**Saints Peter and Paul Christian Primary School – Stage 1 – 17-19 Kosovich Place, Cecil Park (SSD-9210) – Environmental Impact Statement**

## Attachment A

### Saints Peter and Paul Christian Primary School – Stage 1 – 17-19 Kosovich Place, Cecil Park (SSD-9210) – Environmental Impact Statement

Figure 2 Vegetated Riparian Zone

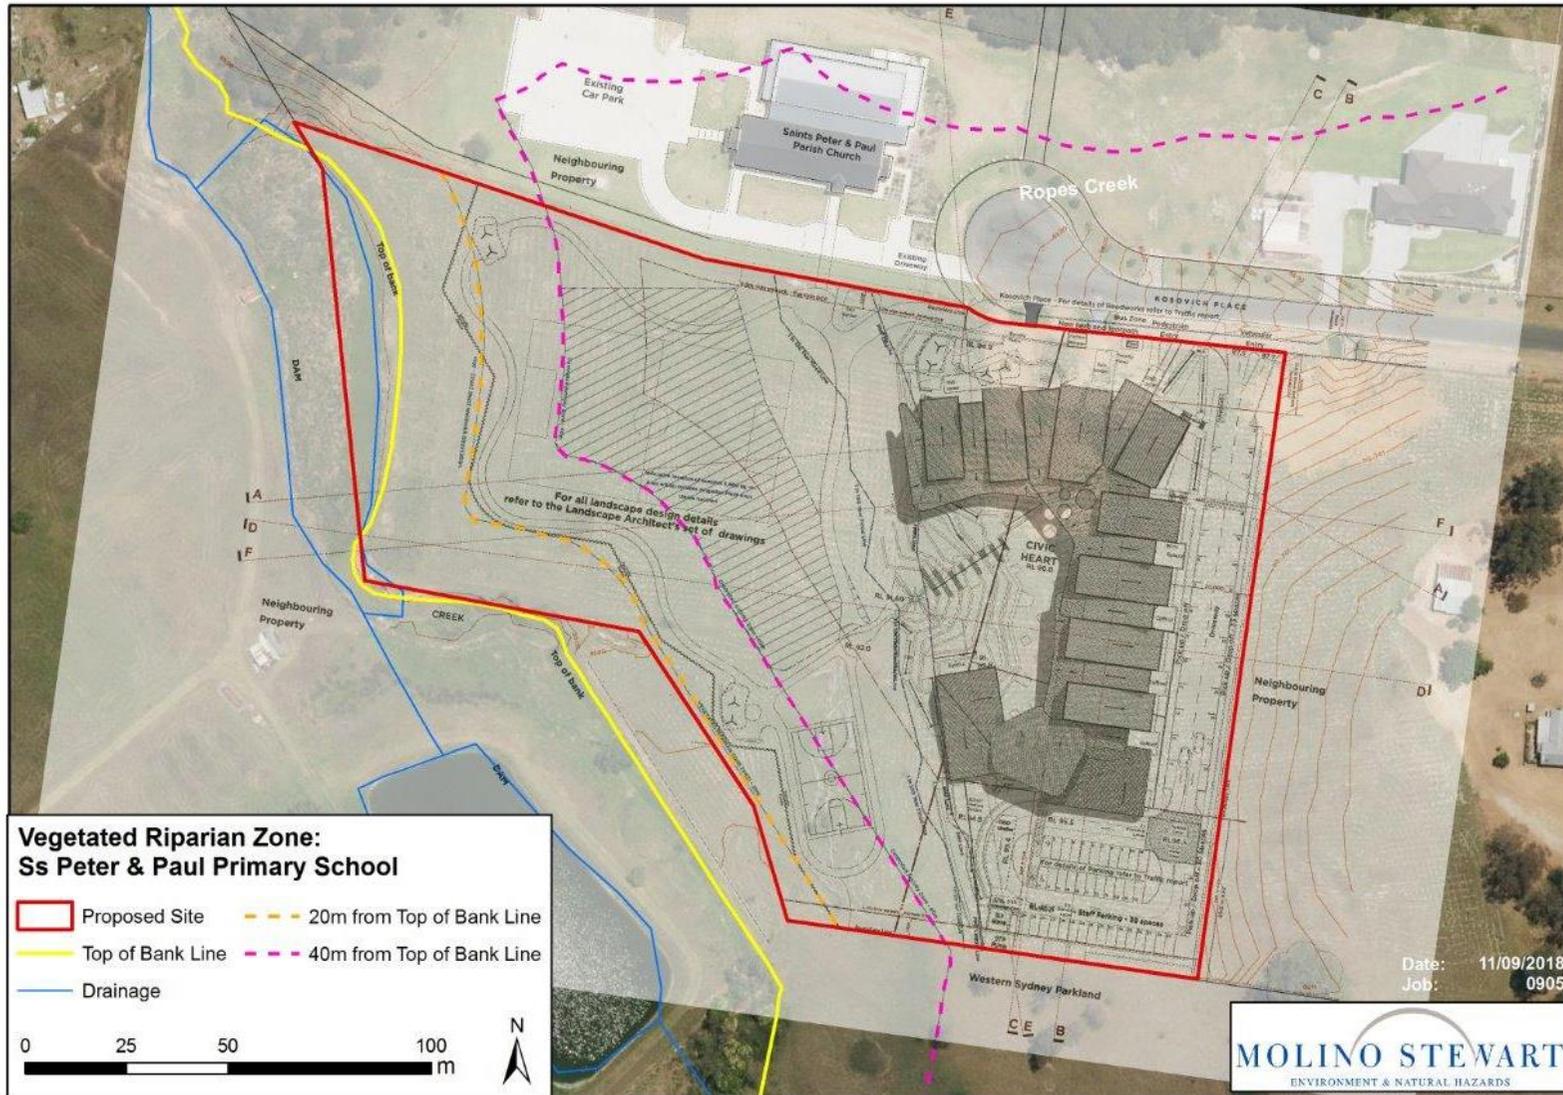
OEH notes the width of the riparian corridor is proposed to be consistent with the DOI Water (2012) guidelines. If there is any opportunity to widen the rehabilitated riparian corridor width along the creek on the site, OEH encourages this, particularly as the watercourse links to the Western Sydney Parklands to the south of the site and to Ropes Creek to the north. The OEH (2011) *Conservation Management Notes - Wildlife on your property - Corridors and Connectivity* looks at how corridors might be used to maximise the wildlife habitat value of a fragmented landscape. It indicates the wider the corridor the better. This is because wider corridors are more resilient to edge effects and provide greater habitat value. A copy of the OEH Conservation Management Note can be found at the following link:

The Riparian Zone Management Assessment recommends undertaking a site survey to accurately identify the location of the watercourse, the riparian corridor and the top of bank (page 10). OEH notes the NSW Department of Industry controlled activities guidelines require the width of the vegetated riparian zone to be measured from ‘the top of the highest bank’. It is suggested the site survey identifies ‘the top of the highest bank’ as per the Department of Industry controlled activities guidelines:

Figure 4 Vegetation management areas

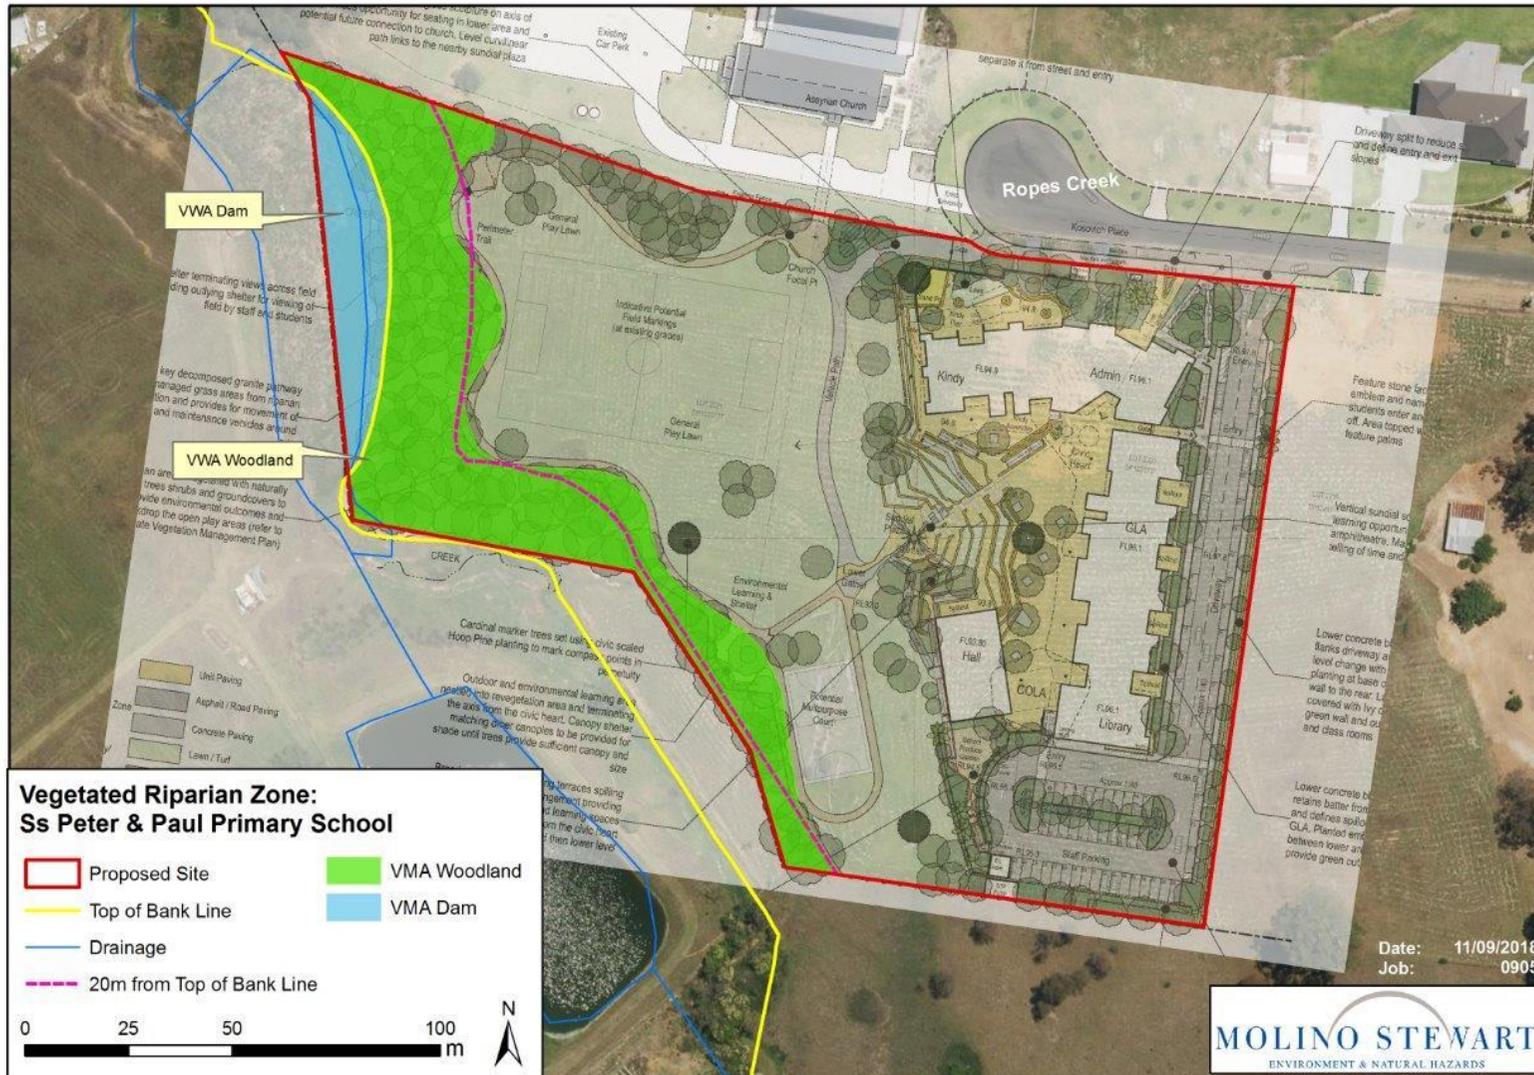
The VMP lists some locally occurring native species of tree, shrub and groundcovers to be used in the revegetation and it notes the list could be expanded to include further species from the RFEF. In terms of improving plant diversity OEH recommends the plant list is expanded and the VMP is amended accordingly.

The VMP indicates the “*specific location and densities would be subject to future detailed design*” (section 4.5.2). This information needs to be provided and it is recommended the VMP is amended to include this detail.

The VMP notes there will be a 3-year monitoring and maintenance period for plantings and weed control works (section 4.7). It is recommended the maintenance of weeds continues in perpetuity. Ongoing management and maintenance of the riparian corridor is a great educational resource for the school.

- 1) The Vegetation Management Plan is amended to include:
  - details on the location, plant species and densities to be planted in the riparian corridor

- an expanded list of locally occurring native tree, shrub and groundcover species characteristic of River-Flat Eucalypt Forest to be used in the revegetation.

**Figure 7 – Asset Protection Zone Plan.**

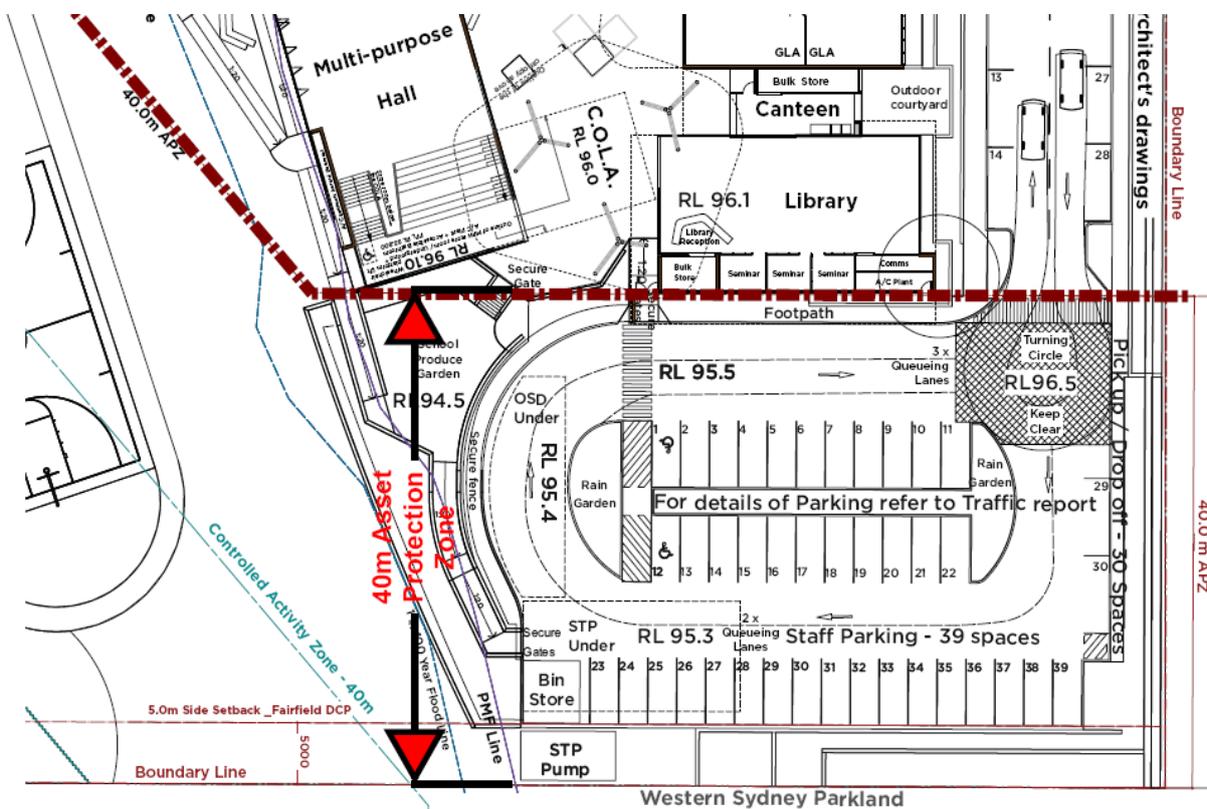
The EIS indicates a 40m wide Asset Protection Zone (APZ) is required to be provided on the site measured from the riparian corridor and from the site's southern boundary which adjoins the Western Sydney Parklands. It is noted the whole of the school site (excepting the riparian corridor) shall be maintained to comply as an Inner APZ (page 115).

OEH agrees the APZ requirements for the development need to be provided on the site and for the purpose of defining the required APZ along the Western Sydney Parklands boundary, the Parklands should be treated as 'woodland' on the basis that while it is currently unmanaged grassland it will restore itself to Cumberland Plain Woodland (see page 123 of EIS).
